Wise Engineering
3915 Old Fairground Rd.
Angier, NC 27501
(919)894-2203

May 22, 2025

Subject: 93 Big J St, Erwin, NC 28339

A representative from Wise Engineering (WE) was on site to observe the home located at 93 Big J St, Erwin, NC 28339. Specifically, we reviewed the following items:

FRONT ELEVATION

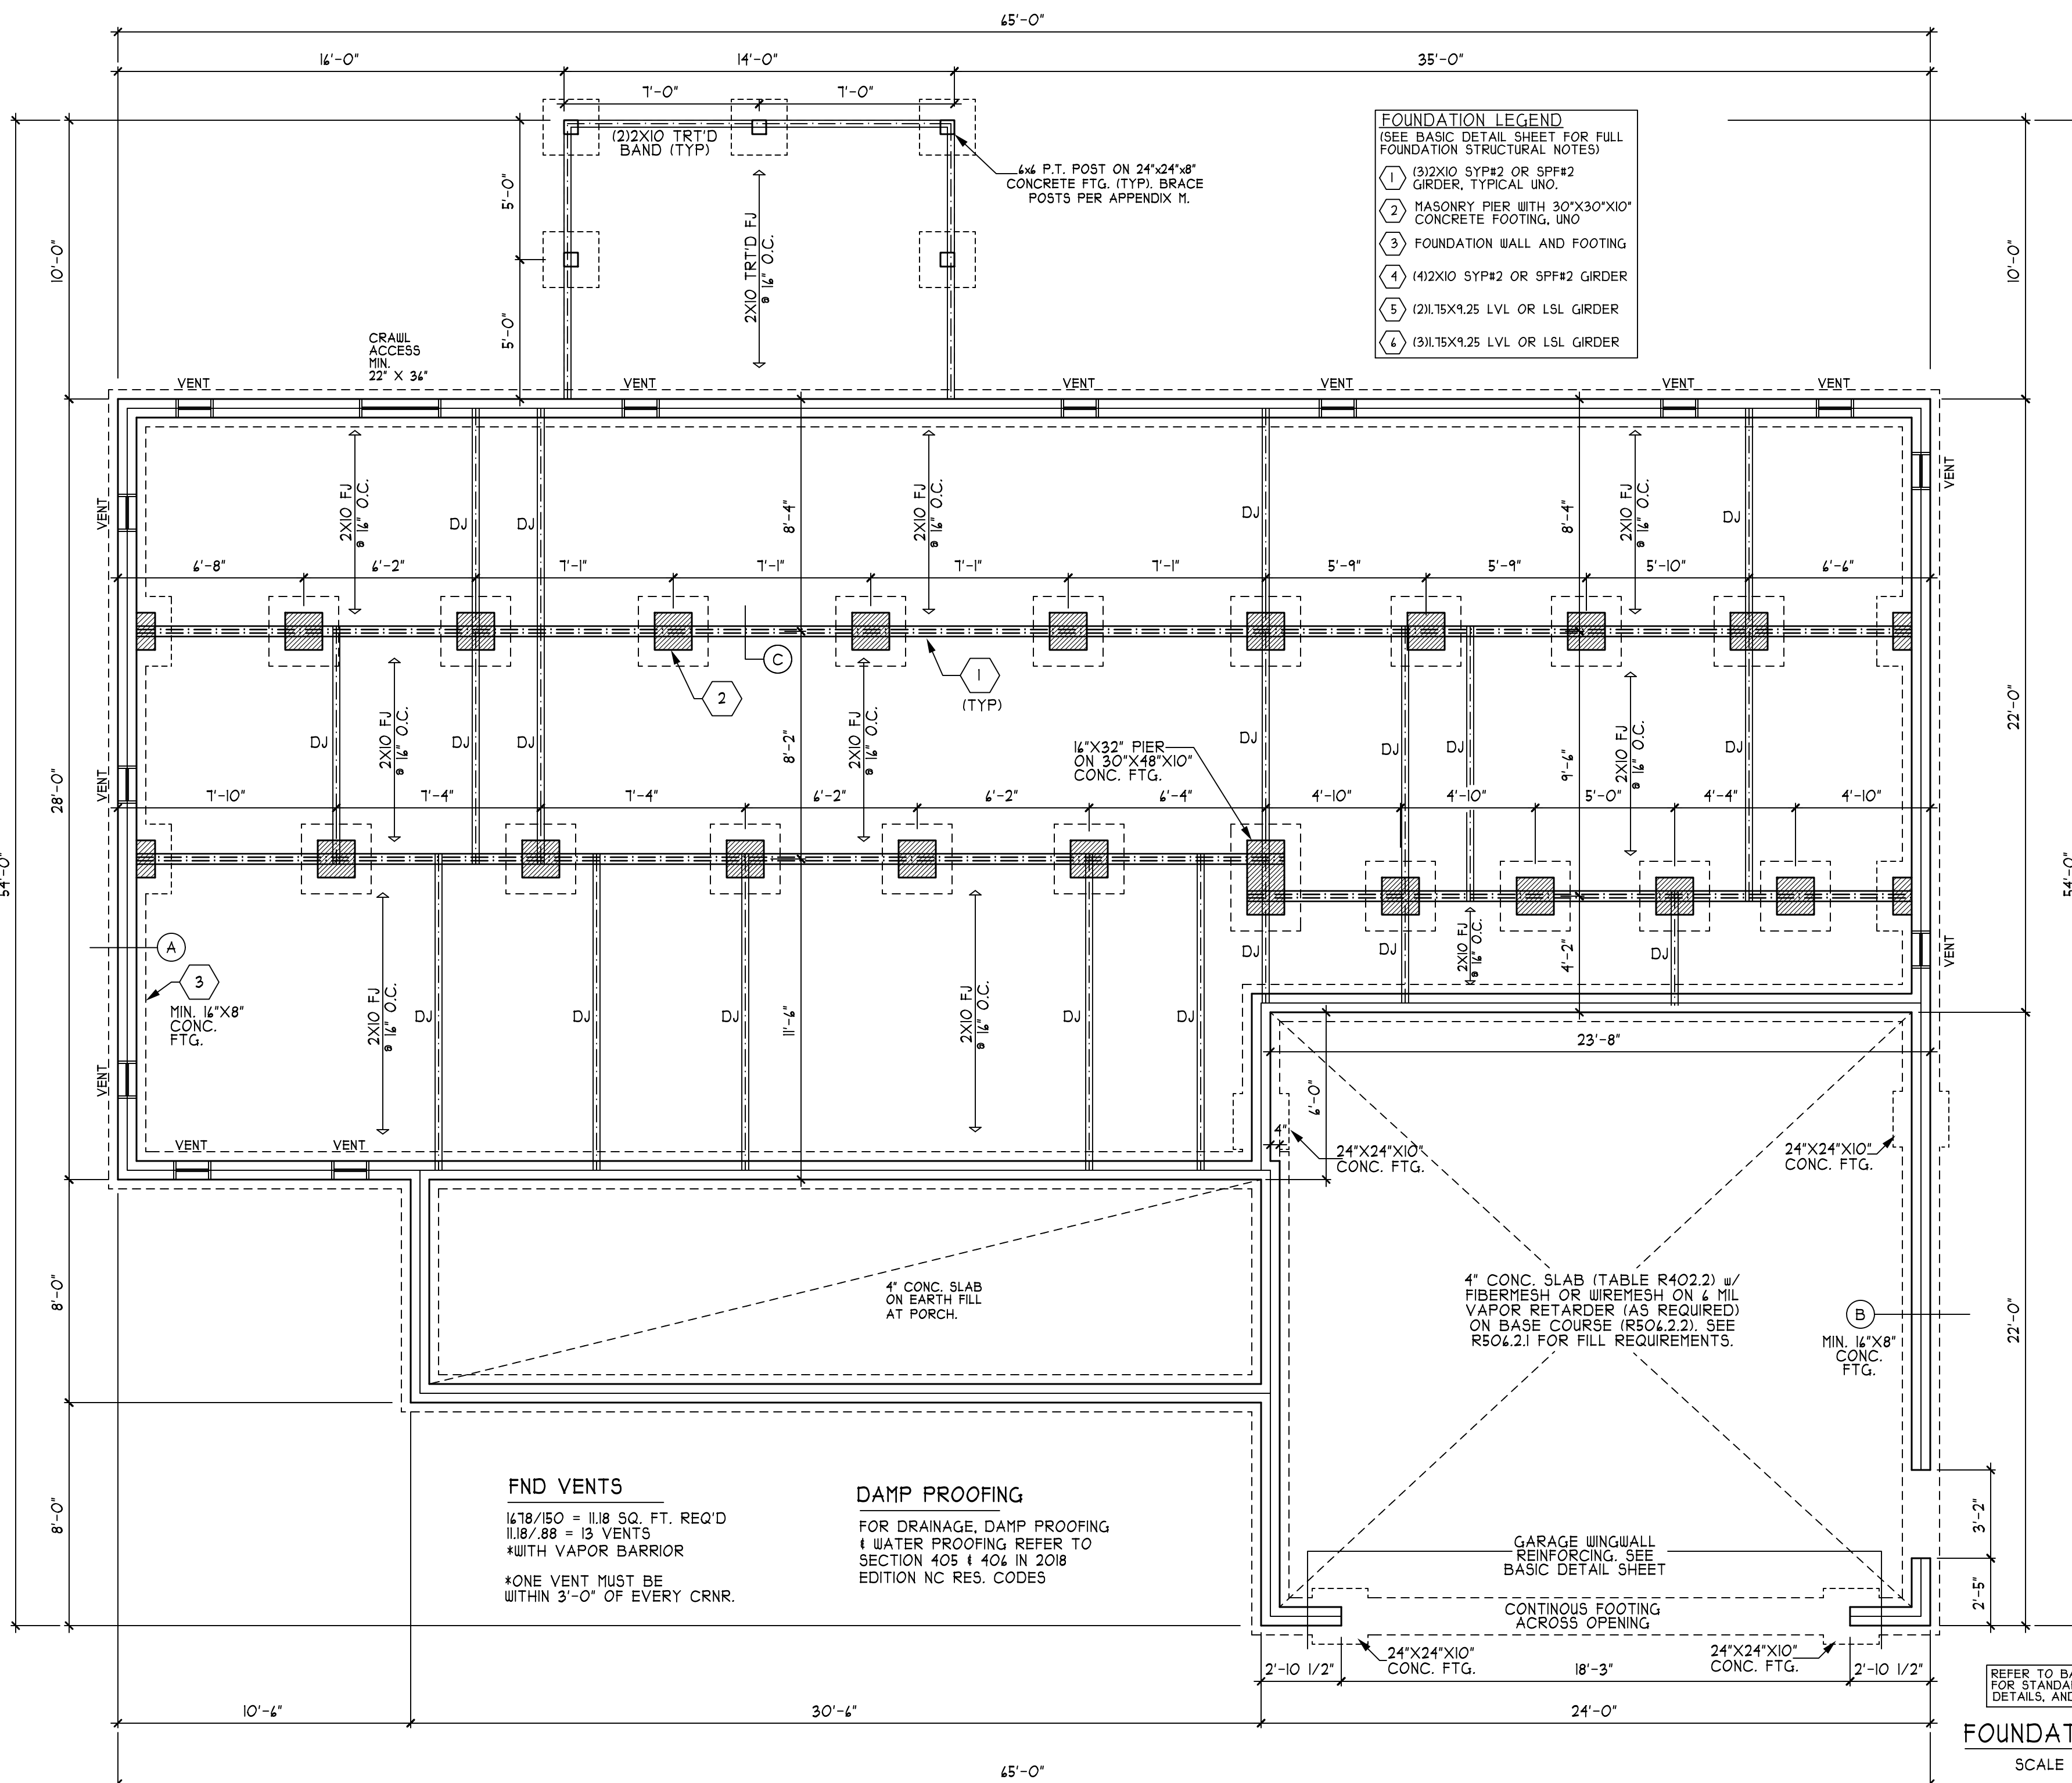
1. The exterior wall studs within the garage
2. The framing of the exterior pony wall over the garage door header
3. Support of the stair stringers at the bonus room
4. Compaction of the #57 stone in the front porch fill

1. The existing double 2x4 studs at 12" on center are structurally adequate to support the anticipated loading conditions.
2. The pony wall over the garage door header should be enhanced by installing a 2x4 to each stud at a 45 degree angle from the midpoint of the pony wall up to the ceiling of the garage to provide lateral bracing. The 2x4's should be secured to the ceiling by attaching a 2x4 perpendicular to the bottom of the roof trusses to secure the diagonal braces to.
3. The stacked 2x4's that support the stair stringers at the bonus room stairs should be secured to the bottom cord of the roof trusses with CS strap that is wrapped around both sides of the bottom cords of the roof trusses.
4. The #57 stone fill for the front porch of the home is structurally adequate without additional compaction after installation.
